13 August 2018

**Section 4.55(1A) Modification to Amend SSD 6848 Lismore Base Hospital
Stage 3B Development**

On 1 May 2015, Stage 3B of the Lismore Base Hospital redevelopment was approved. SSD 6848 has been modified on three (3) occasions (Mod 1, 2 and 3) with a fourth modification application lodged but withdrawn.

1 Building Elevation - North 3B2
A40001 1 : 200

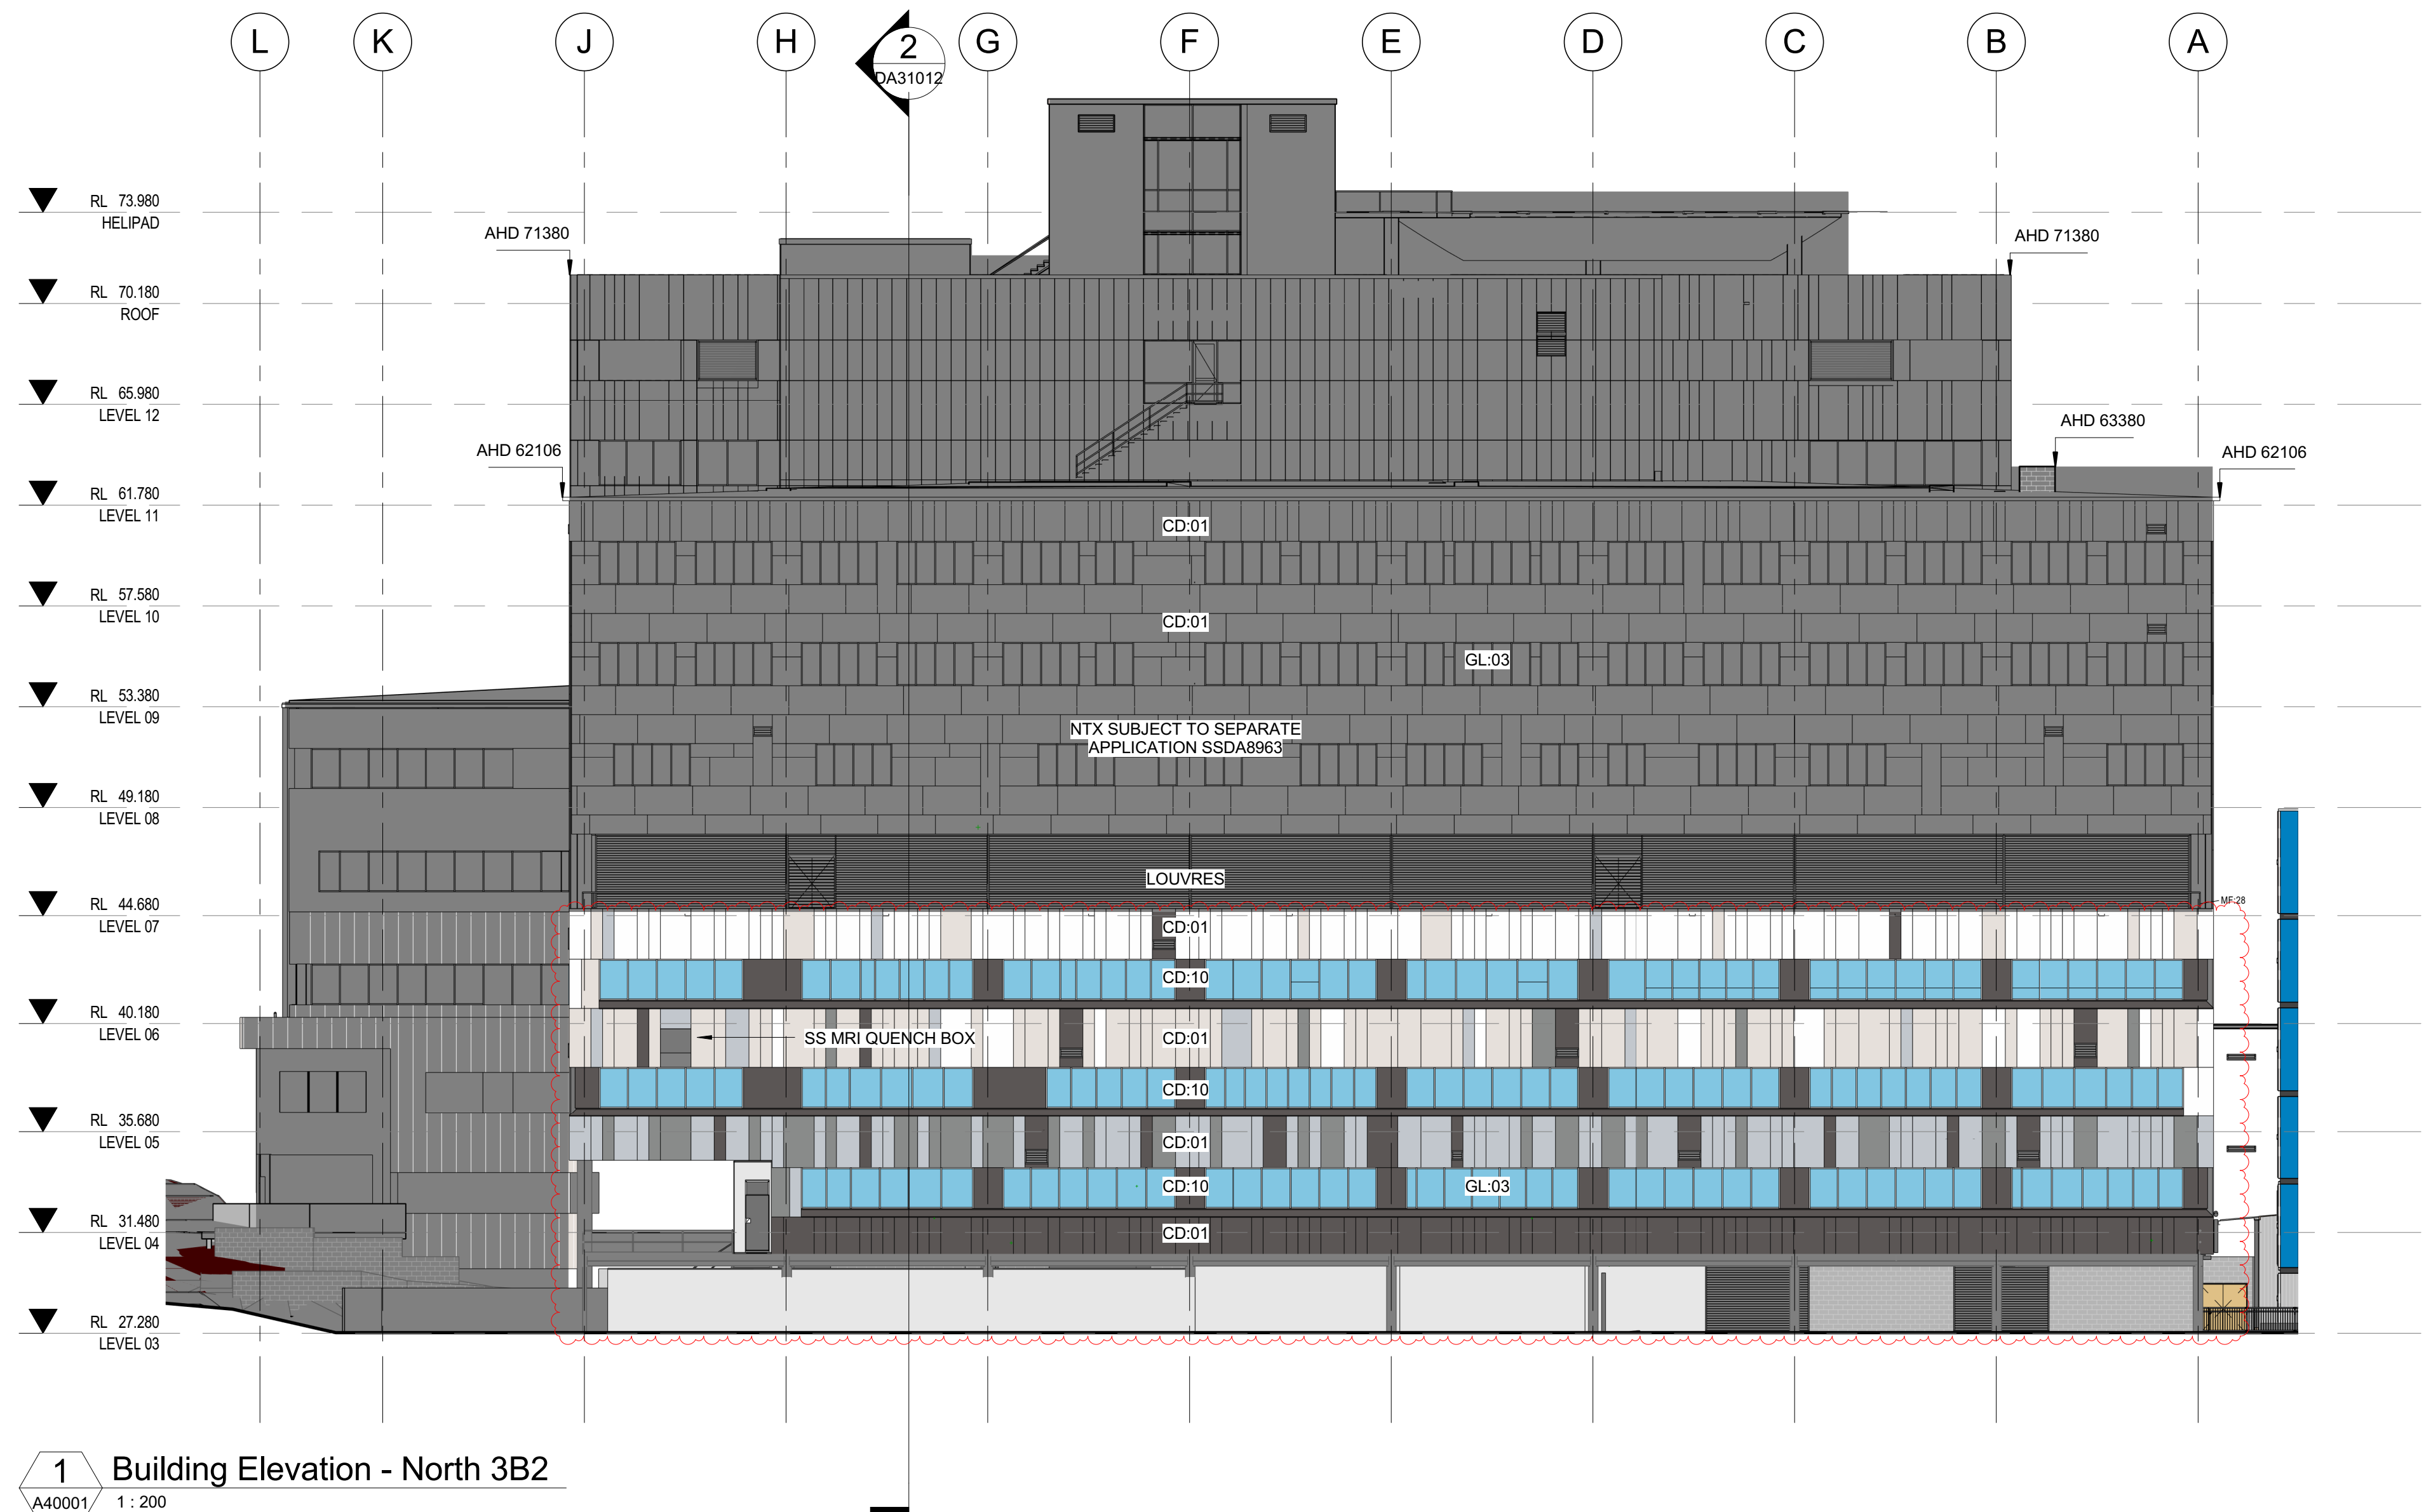
- Amendments to the external façade design and colour scheme of the Stage 3B2 North Tower, as follows:
- Amendment of design language and window placement to the façade (to suit internal layout);
- Change of the façade colour palette to muted/varied greys. Whilst the colour scheme is proposed to be amended, the materials and finishes will remain unchanged;
- Incorporation of quench pipe box and large removable window for MRI; and
- Extent of louvre panelling reduced at Level 03 as a result of the proposed reduction in plant space.

1 GA - Level 04 3B2
A30001 1 : 200

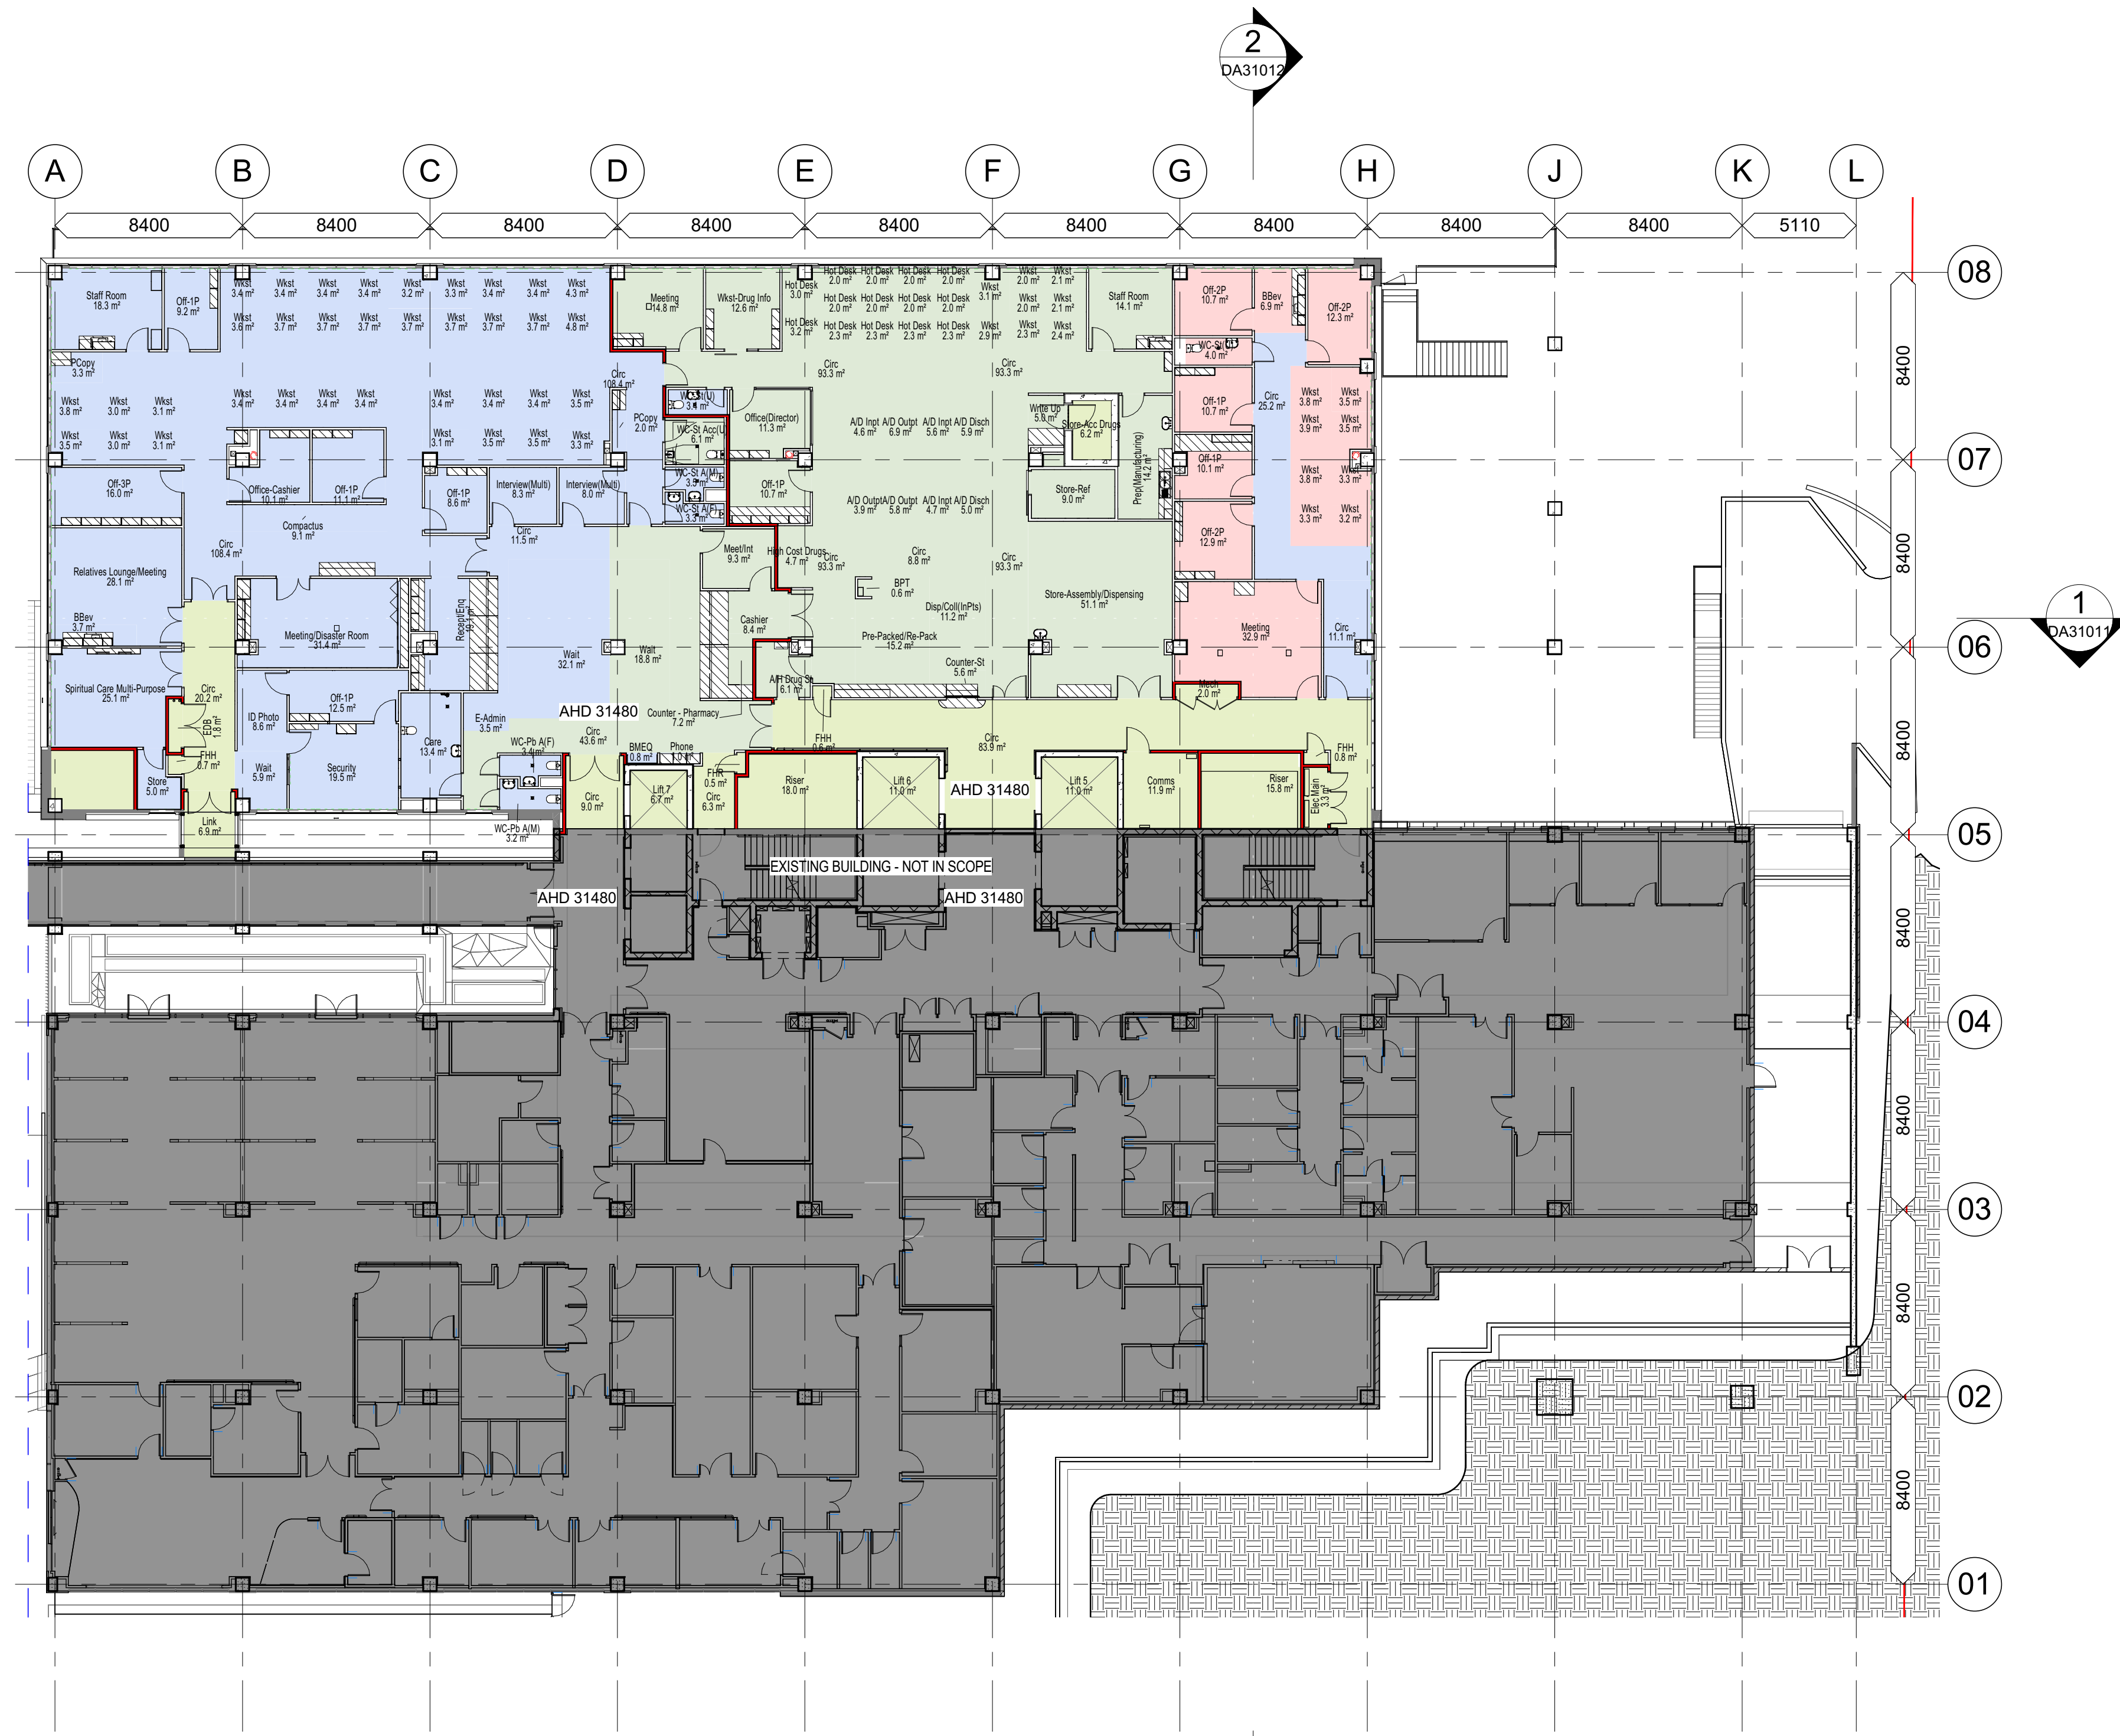
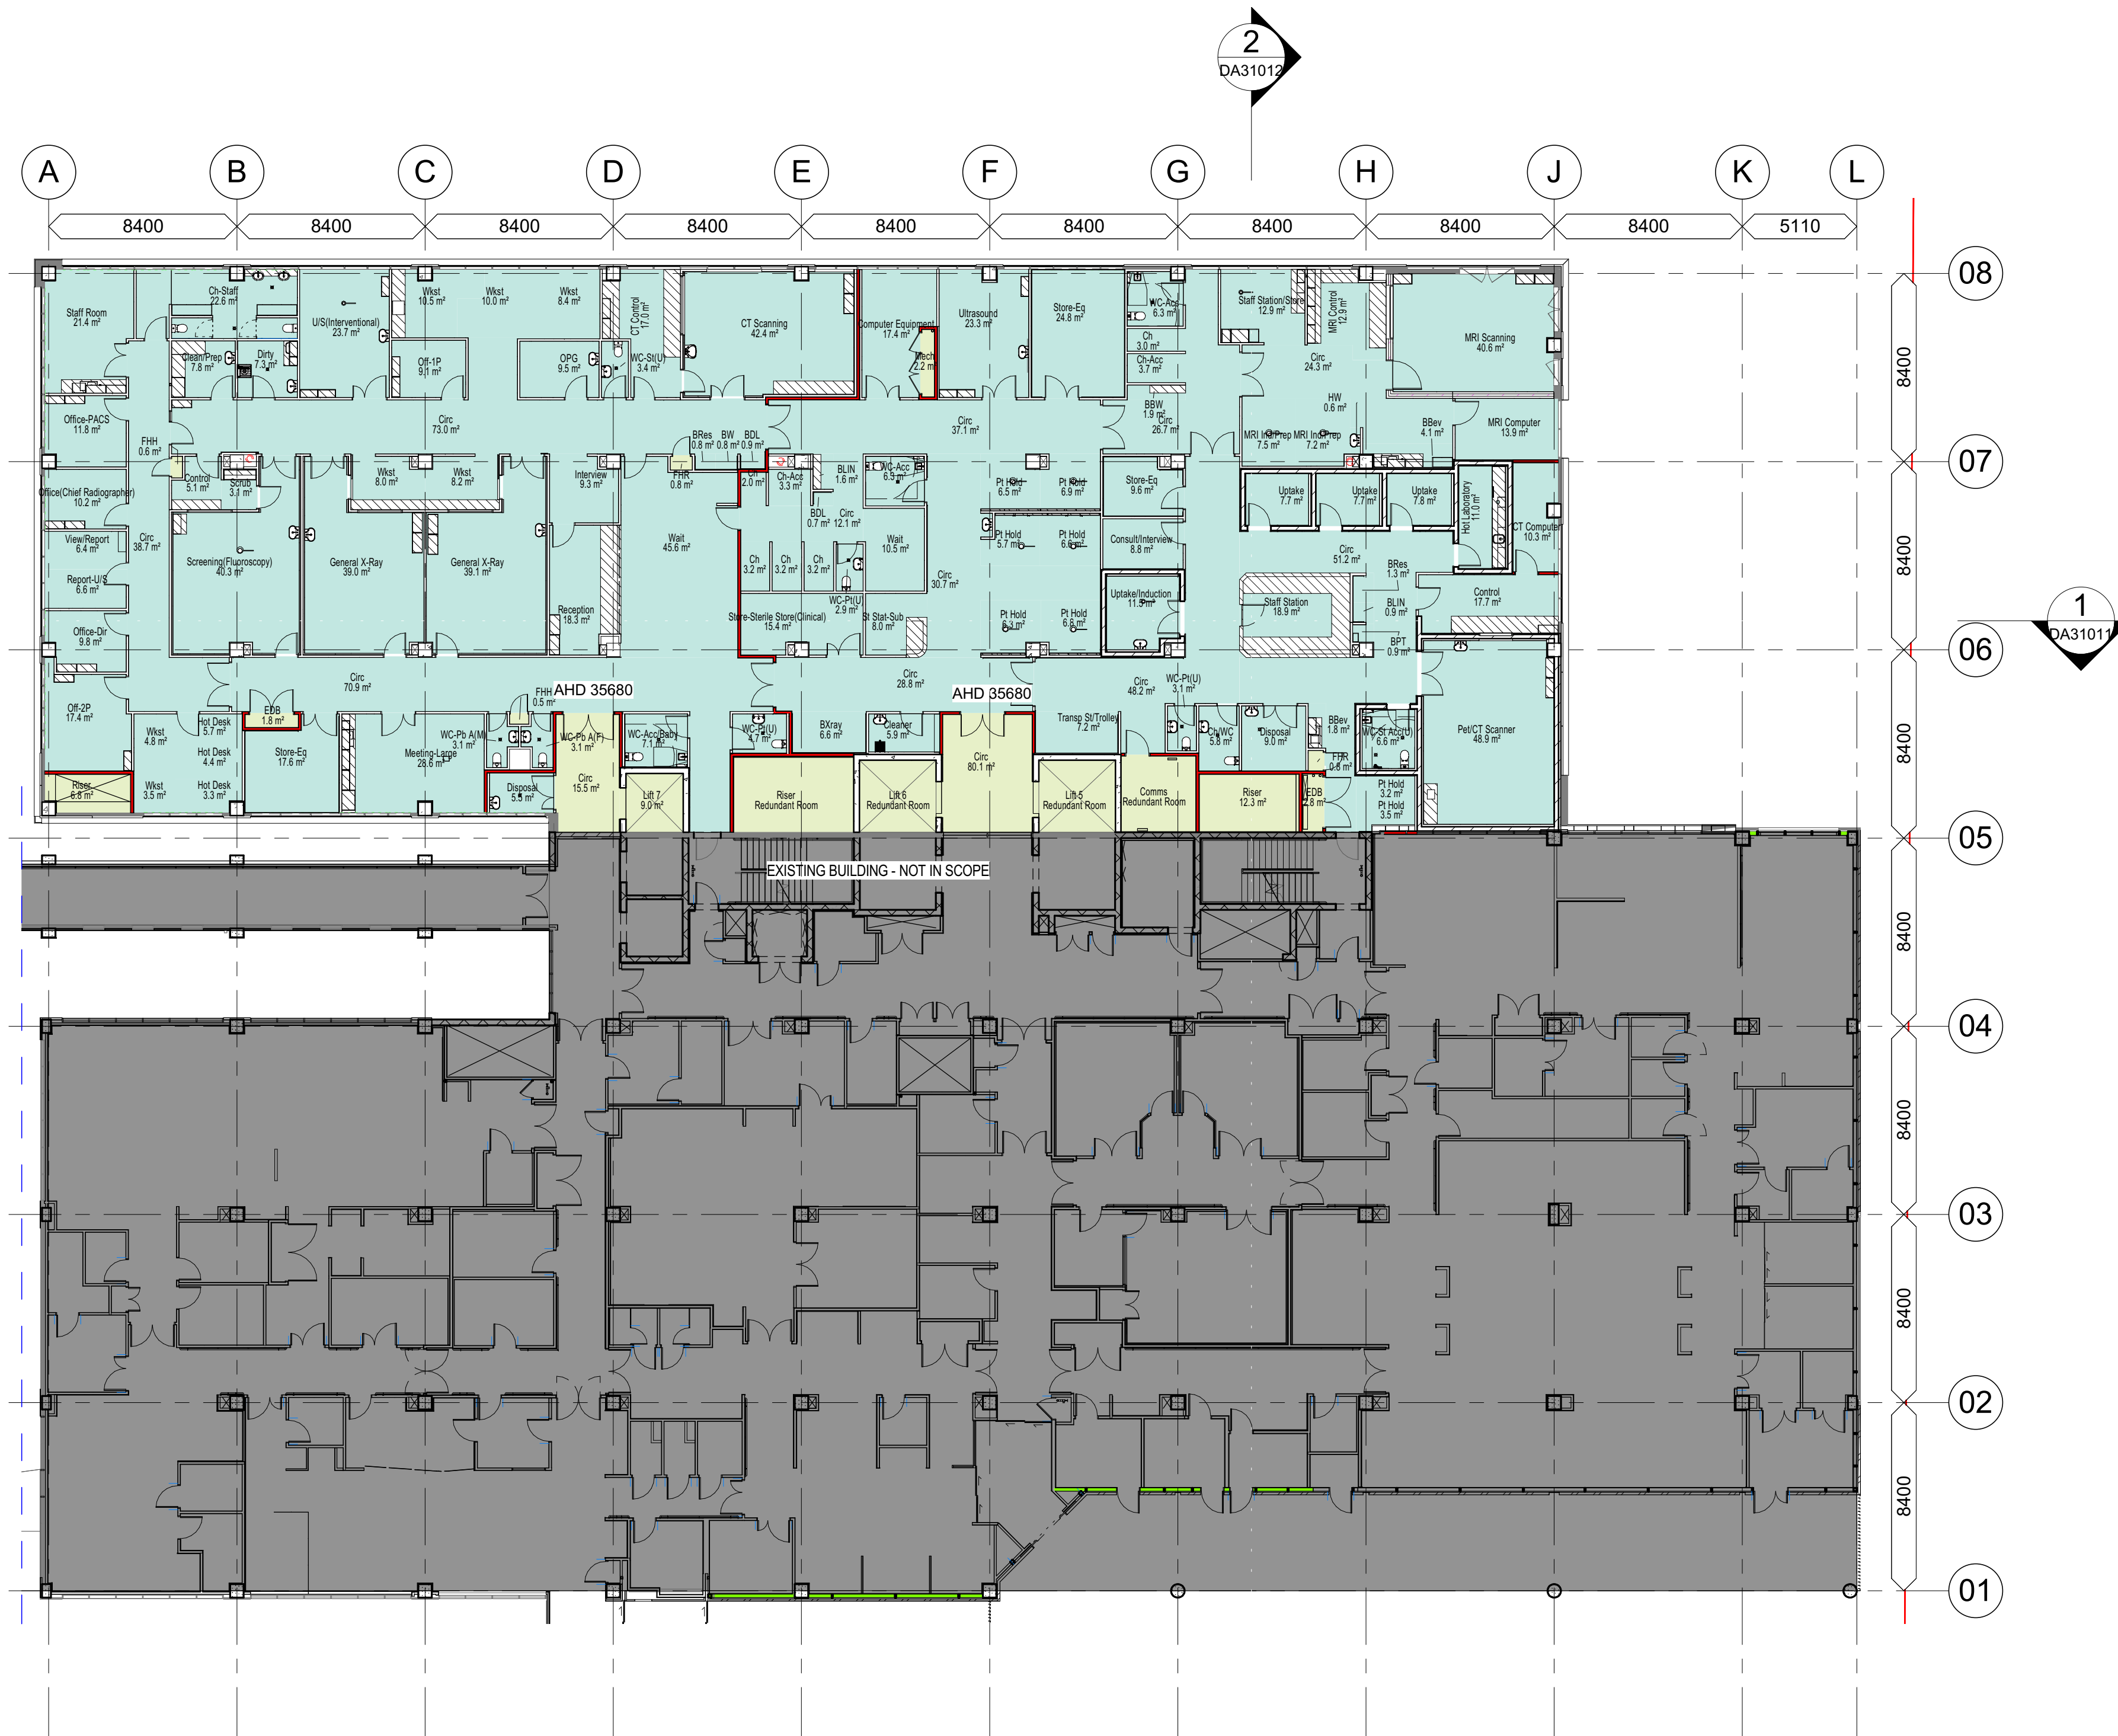
- Minor modifications to the internal layout of Levels 04, 05 and 06, including:
 - Rationalisation of fire compartmentation and overall strategy;
 - Inclusion of an additional public lift within an approved void/shell space (known as “lift 7”);

- Minor modifications to the internal planning of each level to improve functional efficiency, accommodate service risers and penetrations to the future NTX and to respond to by the changes in the location of columns/structural beams; and

- Modifications to the internal face of the external walls as a result of layout changes (such as rationalisation of number of partitions) and the amended façade design (i.e. extent of glazing vs. infill).
